Your reference: MP 09-0203 Mod 1  
Our reference: DOC14/19578-01; EF14/2866  
Contact: Steve Lewer, 4908 6814

## RE: REVIEW OF PROPOSED LONGWALLS 51 AND 52 – WEST WALLSEND COLLIERY ENVIRONMENTAL ASSESSMENT – MODIFICATION 1 TO THE WEST WALLSEND CONTINUED OPERATIONS PROJECT (MP 09-0203 MOD 1)

**ATTACHMENT A: OEH REVIEW OF PROPOSED LONGWALLS 51 & 52 – WEST WALLSEND COLLIERY ENVIRONMENTAL ASSESSMENT: MODIFICATION 1 TO THE WEST WALLSEND CONTINUED OPERATIONS PROJECT (MP 09-0203 MOD 1)**

Figure 3: Proposed modified mine plan

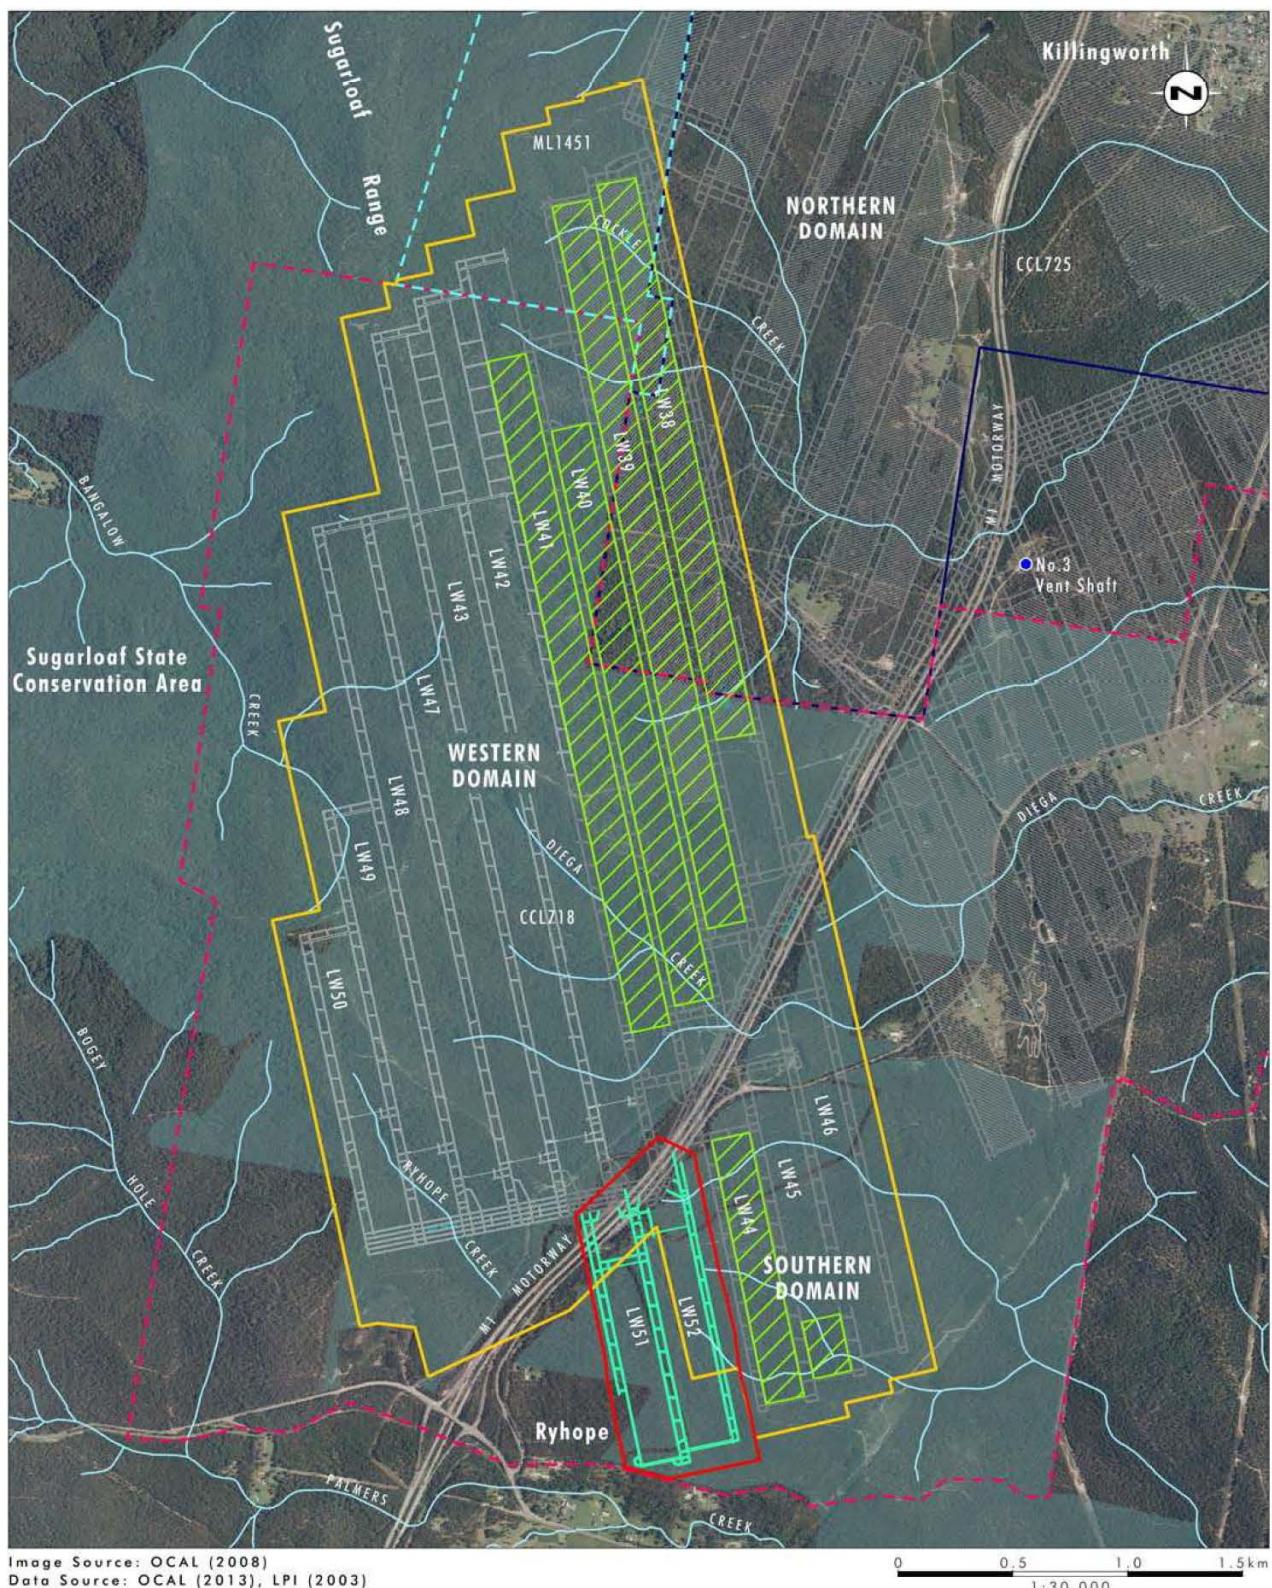
Longwall panels 51 & 52 are proposed to be 178.8m and 206.6m wide. The latter panel represents an increase of 12% over the existing width of longwalls at West Wallsend Mine, which have already resulted in considerable damage to Sugarloaf SCA. Cover depth for the proposal is relatively shallow, ranging from 80m to 140m. Experience in this and other areas (including over the existing West Wallsend mine)

suggests that significant impacts are likely due to the shallow depth of cover and width of the planned longwalls.

The proposal for longwalls 51 & 52 are likely to result in a high level of damage and has not sought to reduce impacts on the basis of previous experience of impacts on Sugarloaf SCA. This could be achieved through narrowing pillars and widening panels (approaches adopted in other parts of the mine), but instead the current proposal increases the width of longwall 52 by 12% over existing longwall panel widths. Any trade-offs between extraction of coal and public safety, public access and the conservation values of Sugarloaf SCA need to be explicit. The social and environmental consequences of this damage to the SCA are considered to potentially be understated in the EA and there is a lack of appropriate monitoring of groundwater aquifer levels or connective fracturing above the proposed longwalls. In addition, the public safety, public access and conservation values of Sugarloaf SCA have not received any appropriate valuation for the proposal and are not included in any part of the cost-benefit analysis for the proposal.

Figure 9: Predicted height of A-Zone fracturing for LW 51

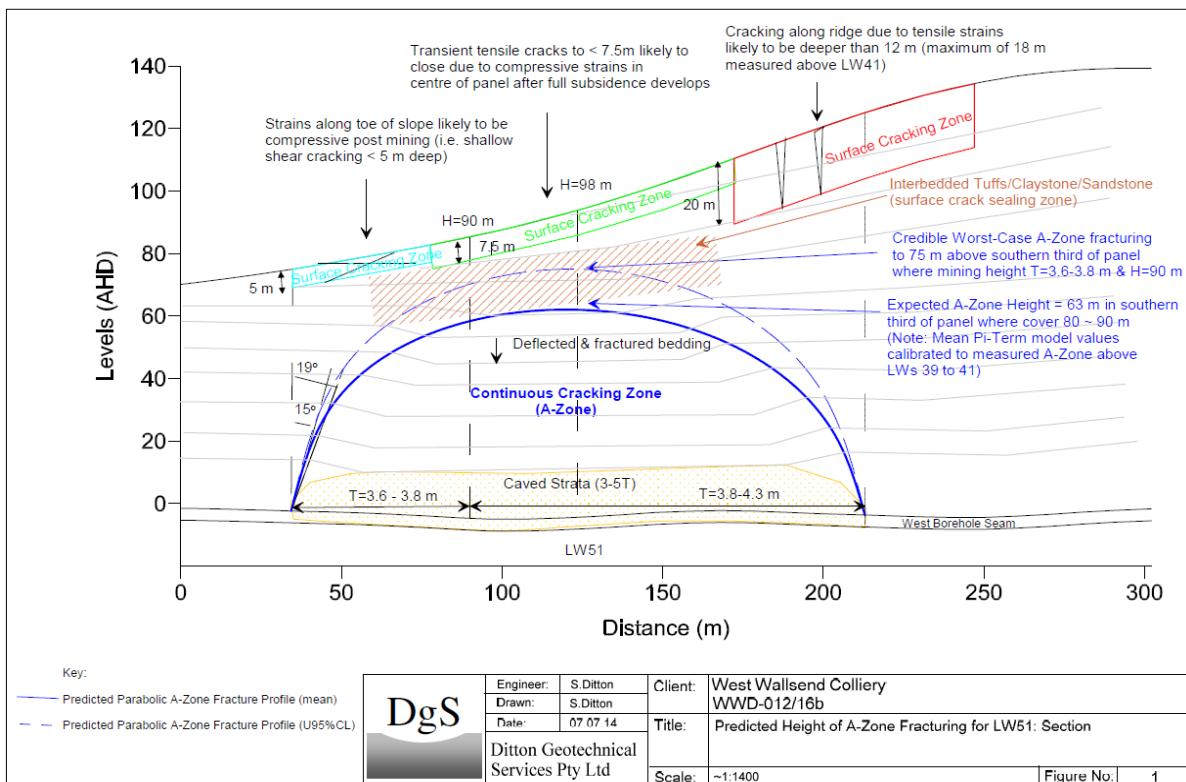
The EA (pages 33-41, and Appendix 3) indicates that connective cracking at cover depths of 80m is "unlikely" if the mining height is reduced to 3.6m in LW51. However, the data presented does not appear to support this conclusion. Appendix 3, page 60, indicates the minimum A-Zone fracture heights above LW51 (at mining height of 3.6m) is 55-66m, while the B-Zone thickness values range between 21-24m and the D-Zone surface cracking depths are estimated to range between 10-12m. These data indicate a likely

potential for connective cracking. Even the U95%CL graph presented in Appendix 3, Figure 26b indicates the height of the continuous cracking lies very close to the 12m below surface line which is the estimated distance of surface cracking. This regression equation within the U95%CL graphs (Appendix 3, 26a & 26B) is dependent upon the three measured variables, all of which have been taken at cover depths between approximately 97m to 155m depth of cover so the cover depth estimations at 80m and 90m are extrapolations of the data and hence the predictions are less reliable in this section of the curve.

Further details should be provided to justify that connective cracking should not occur as a result of longwall mining as detailed in the EA.
